Planning and Development Acts 2000 to 2019

Planning Authority: Dún Laoghaire-Rathdown County Council

Planning Register Reference Number: Ref4019

WHEREAS a question has arisen as to whether decorative works to the front elevation, specifically the painting of all walls within the entrance portico a blue-grey colour, (Dulux reference 90BG-27-079), at the Royal Irish Yacht Club, Harbour Road, Dún Laoghaire, County Dublin (a Protected Structure) is or is not development or is or is not exempted development:

ELEVATION AFTER PAINTING

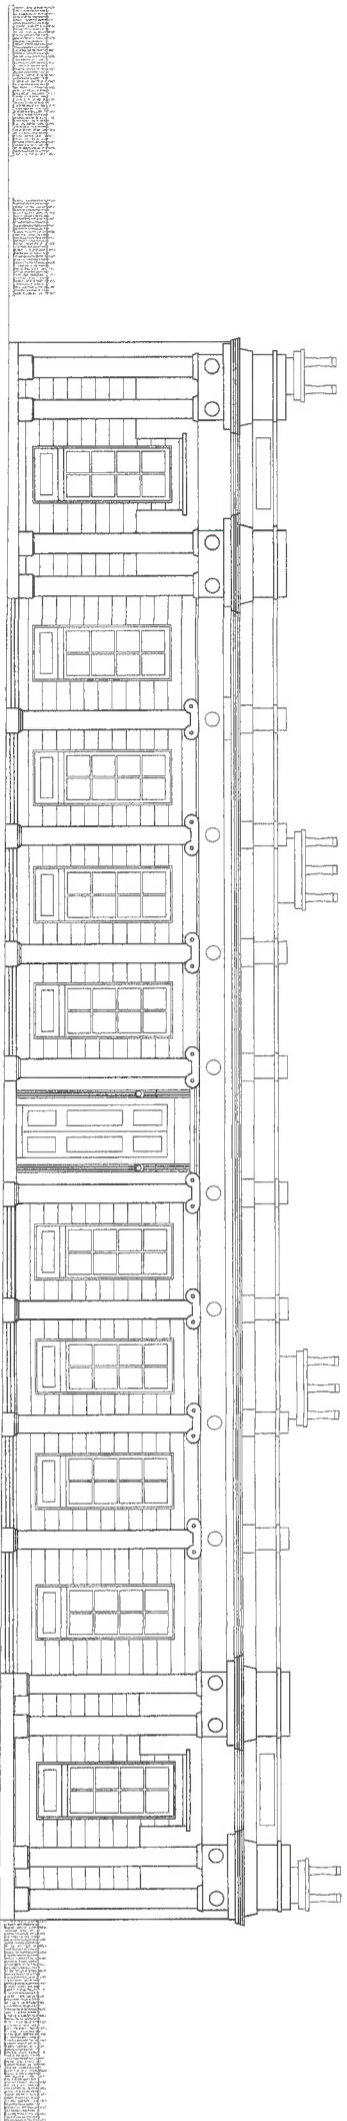
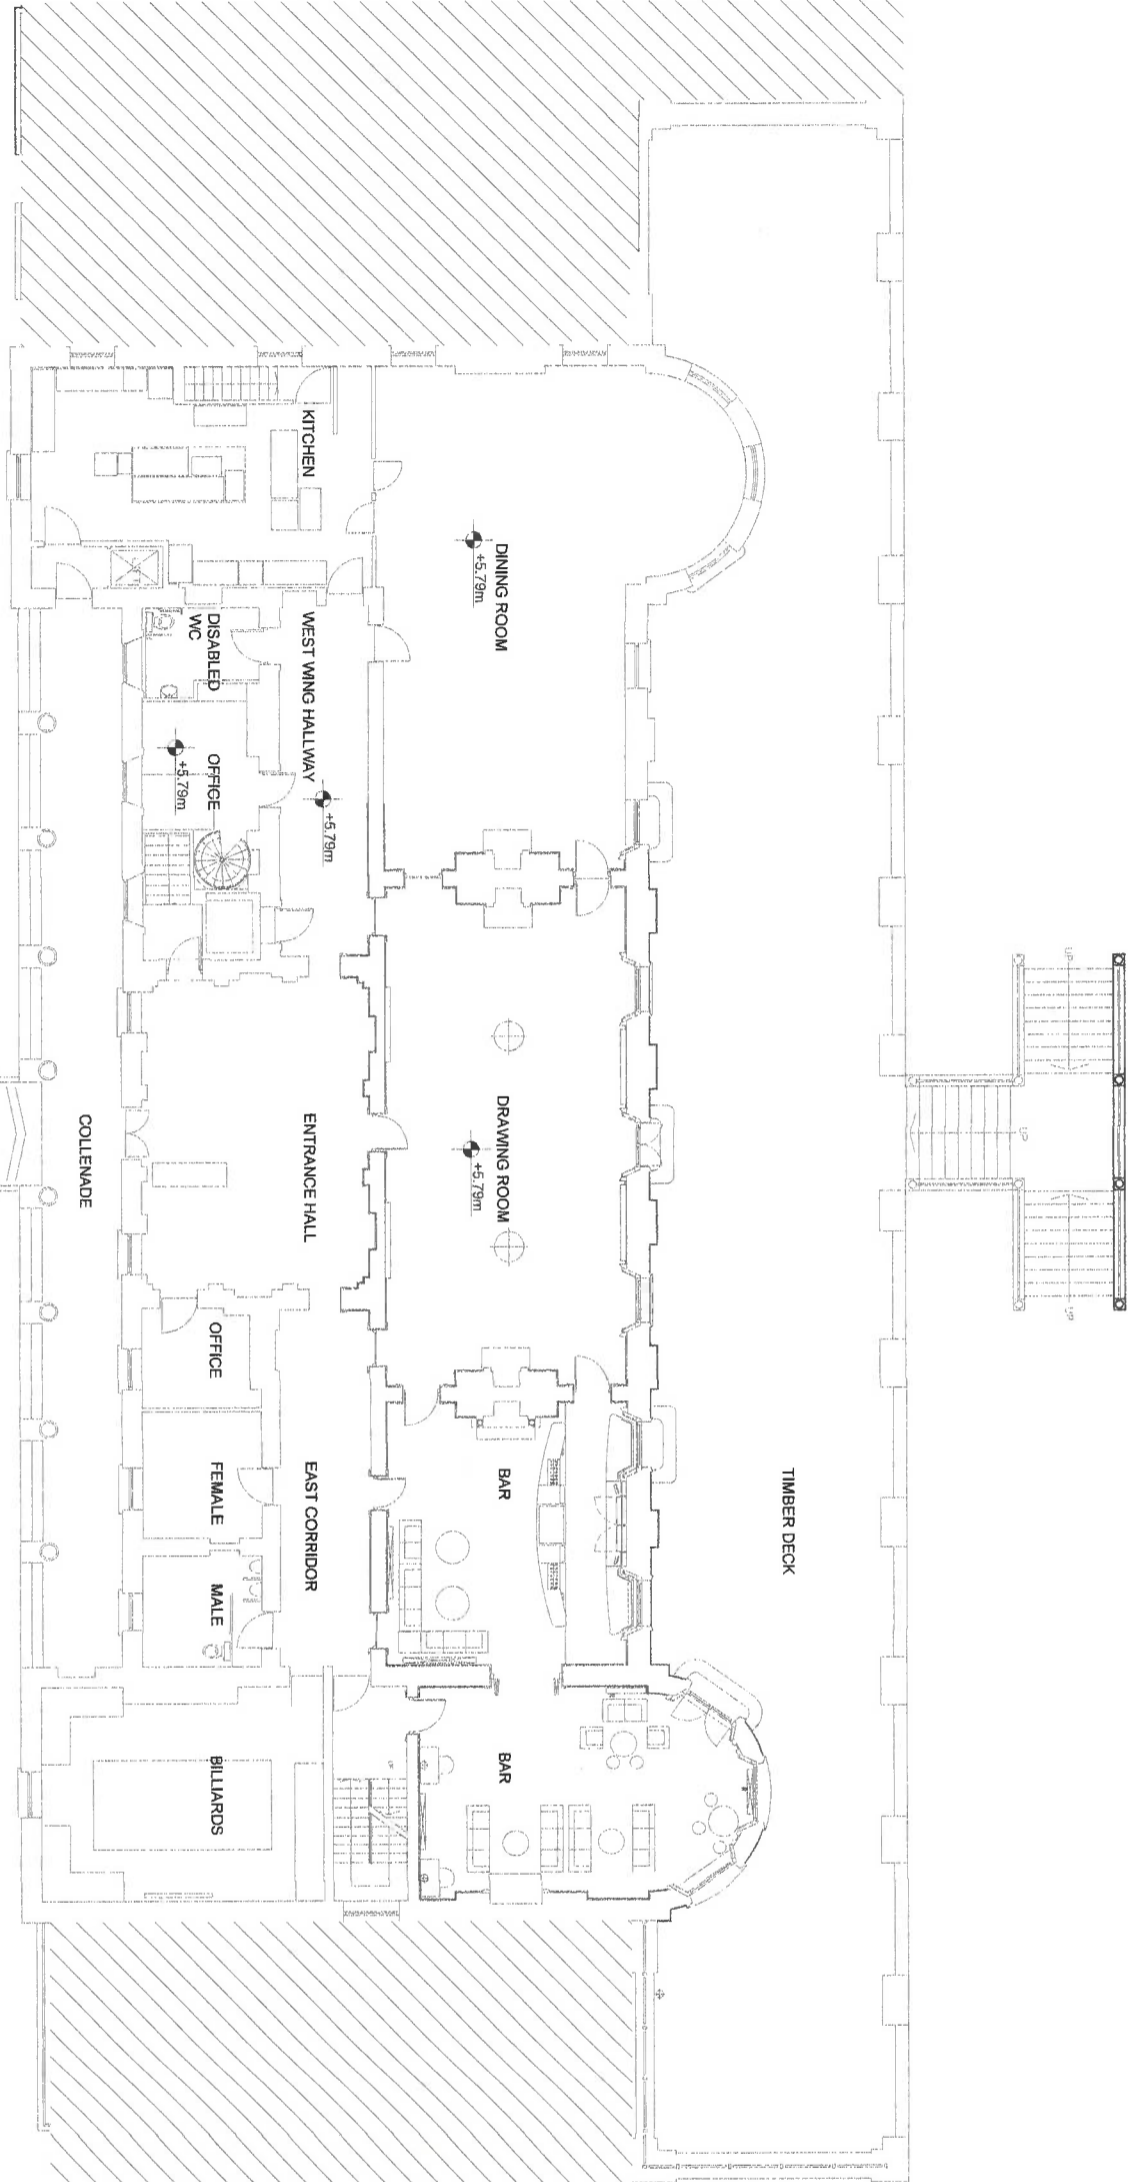
- (a) the works of painting of all walls within the entrance portico of the building a blue-grey colour constitute development which comes within the meaning of section 2(1) and section 3(1) of the Planning and Development Act, 2000, as amended,
- (b) these works might have come within the scope of Section 4(1)(h) of the Planning and Development Act, 2000, as amended, however these works cannot avail of the exemption having regard to Section 57 of the Planning and Development Act, 2000, as amended:

- (c) such works would materially affect the external appearance of the structure so as to render the appearance inconsistent with the character of the structure, and would materially affect the character of the Royal Irish Yacht Club Protected Structure, the uniform off-white paint finish to the exterior is an element of the structure which contributes to its special architectural interest,
- (d) works have, therefore, been undertaken to a Protected Structure that materially affect the character of an element of the structure which contributes to its special architectural interest, and the subject works cannot, therefore, avail of any exemption provided for under the relevant legislation, and
- (e) the works do not, accordingly, come within the scope of section 4(1)(h) or section 57(1) of the Planning and Development Act, 2000, as amended:

NOW THEREFORE An Bord Pleanála, in exercise of the powers conferred on it by section 5 (3) (a) of the 2000 Act, hereby decides that the decorative works to the front elevation, specifically the painting of all walls within the entrance portico a blue-grey colour, (Dulux reference 90BG-27-079), at the Royal Irish Yacht Club, Harbour Road, Dún Laoghaire, County Dublin (a Protected Structure) is development and is not exempted development.
